Roads and Maritime Reference: SYD12/00236/08 (A20295538)
DP&E Ref: SSD 5175 MOD 3 & SSD 8588

**MODIFICATION TO THE EASTERN CREEK BUSINESS HUB
ROOTY HILL ROAD SOUTH, ROOTY HILL**

In relation to SSD 5175 MOD 3 and SSD 8588 Roads and Maritime have assessed the submitted information provided by the DP&E and the additional information provided by the applicant on the 14 September 2017. Roads and Maritime have the following comments and requests the following additional information:

drawing title PROPOSED SITE PLAN -  
STAGE 1

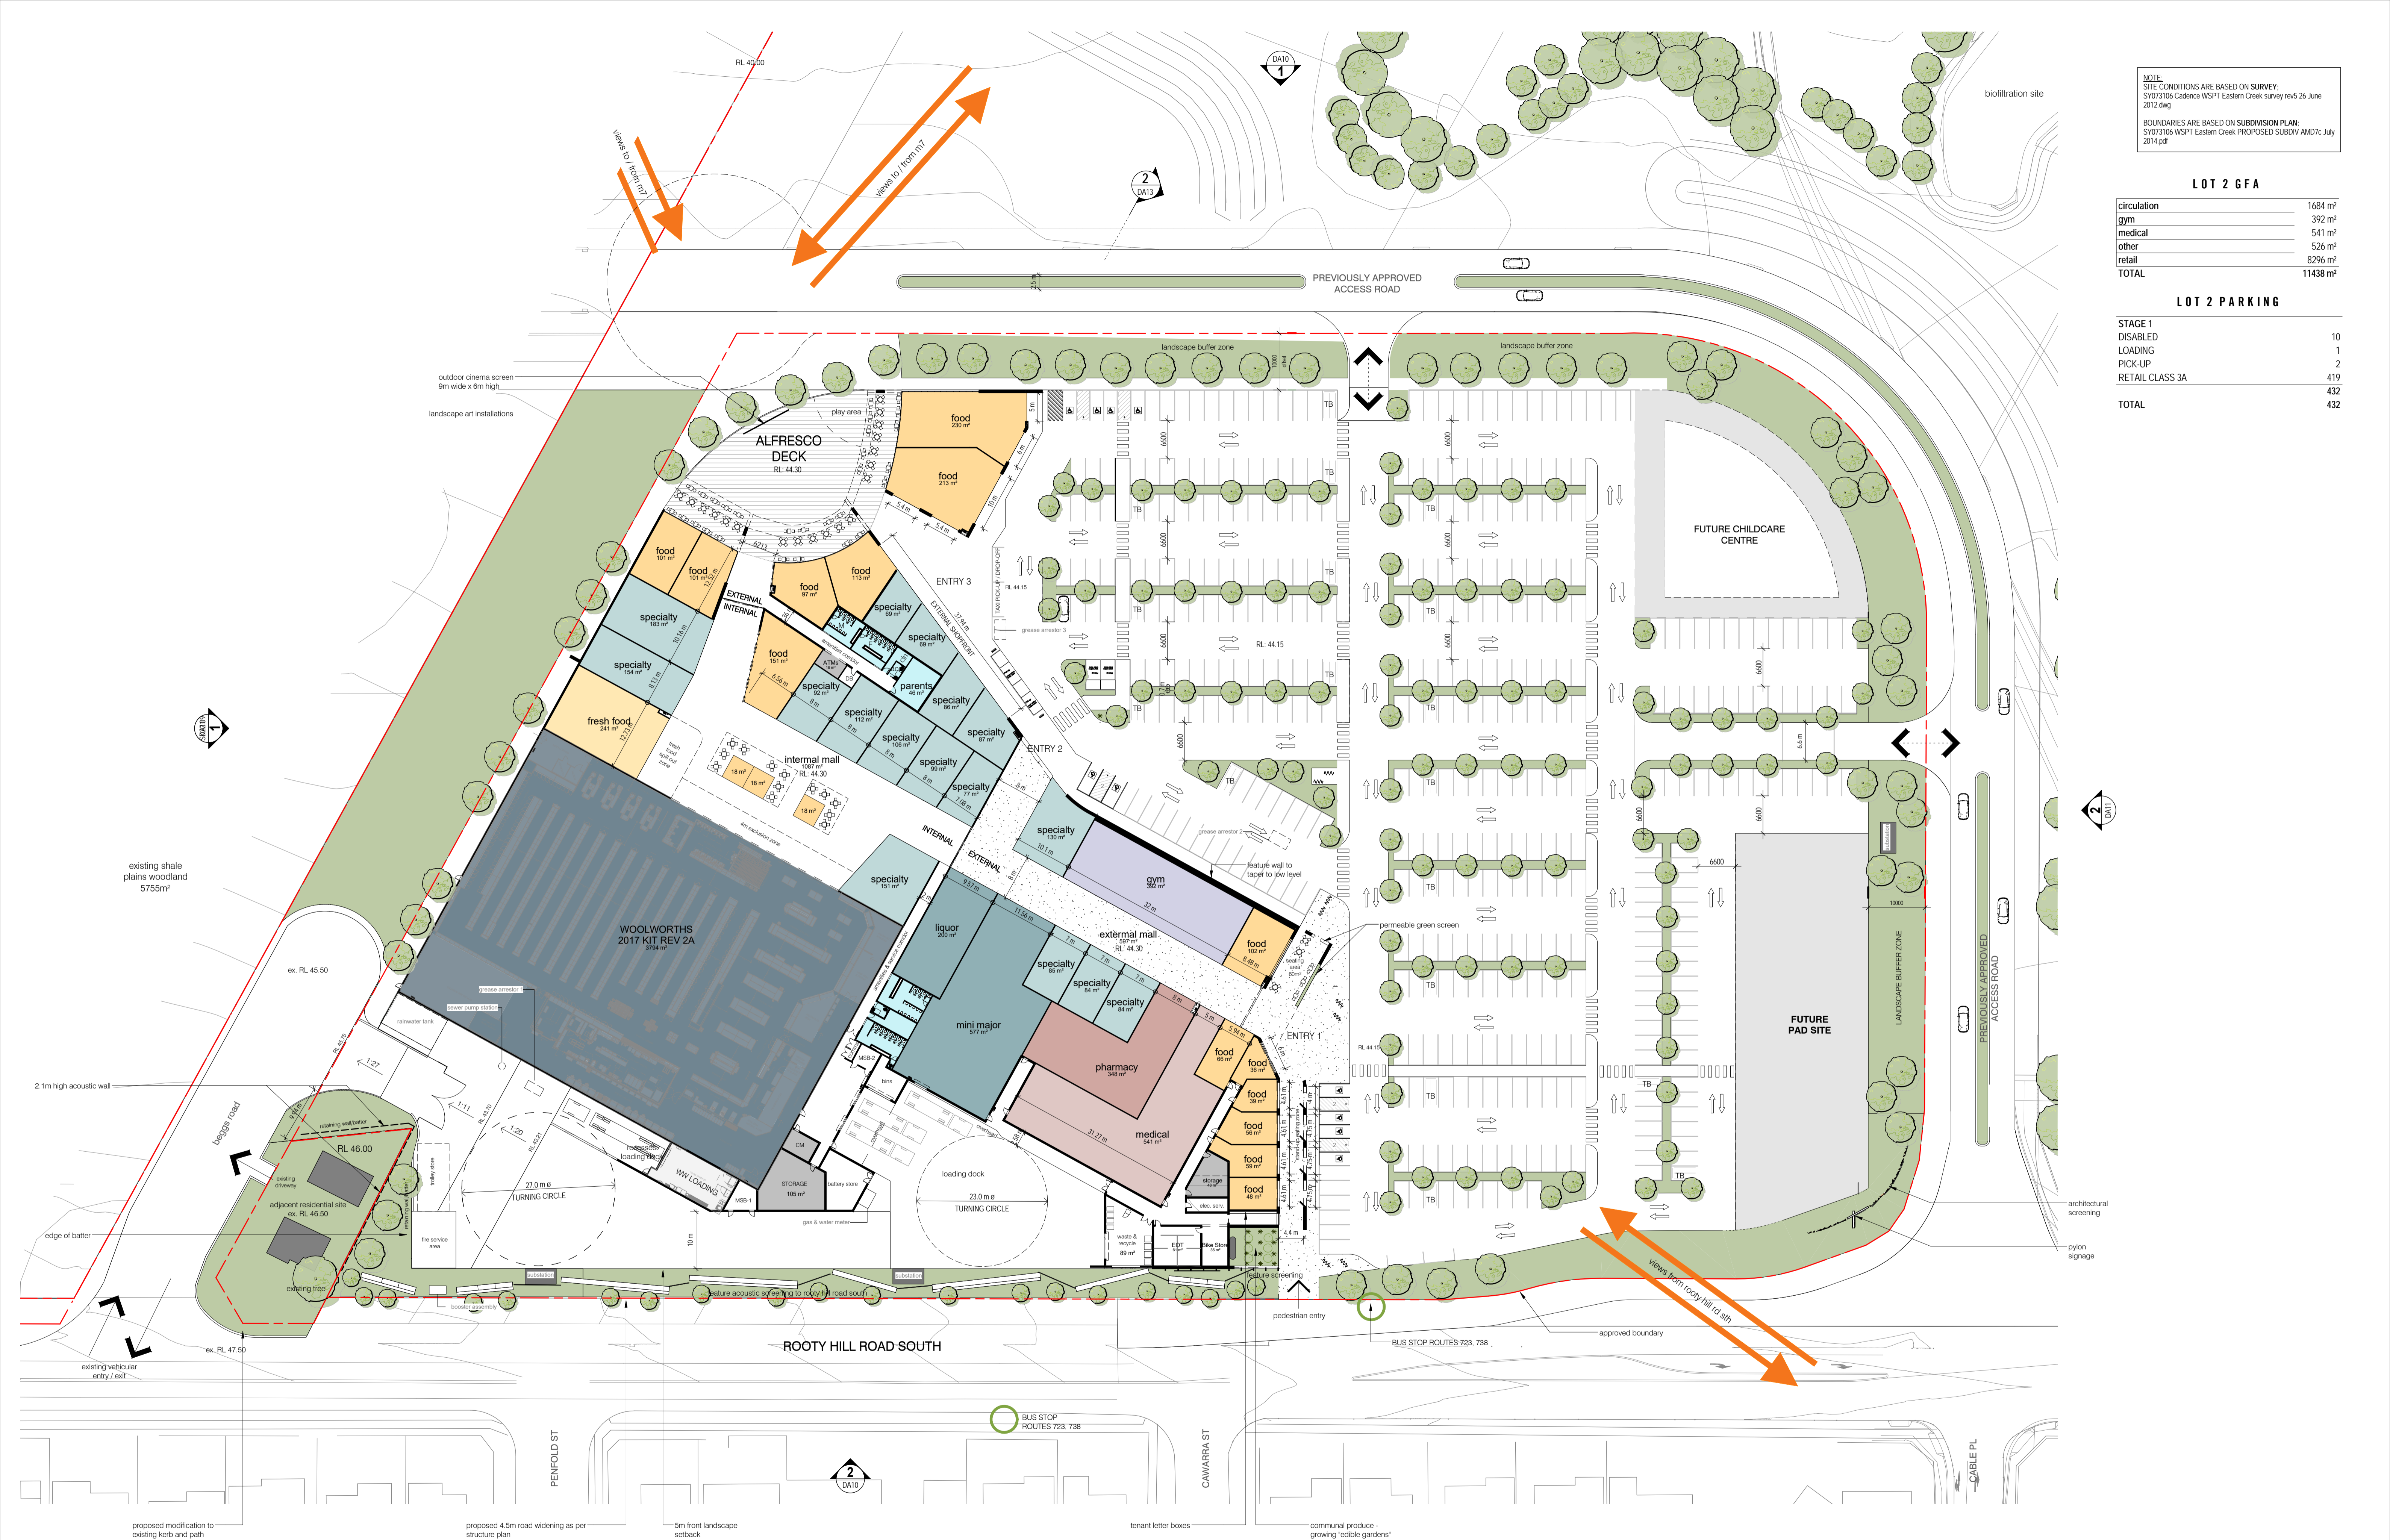
2. The lane widths along Rooty Hill Road South need to be widened to 3.5m this was one of the outcomes from the Corridor Study back in 2014. In this study it was also identified that a central median be provided with pedestrian fencing. A median has been provided but the applicant must provide pedestrian fencing in accordance with TD 2010/RS01. The applicant is to submit plans reflecting these changes.

3. A shared path of at least 3.5m wide should be provided on the eastern side of Rooty Hill Road. A 6.5m wide verge is also required. The applicant is to submit plans reflecting these changes.
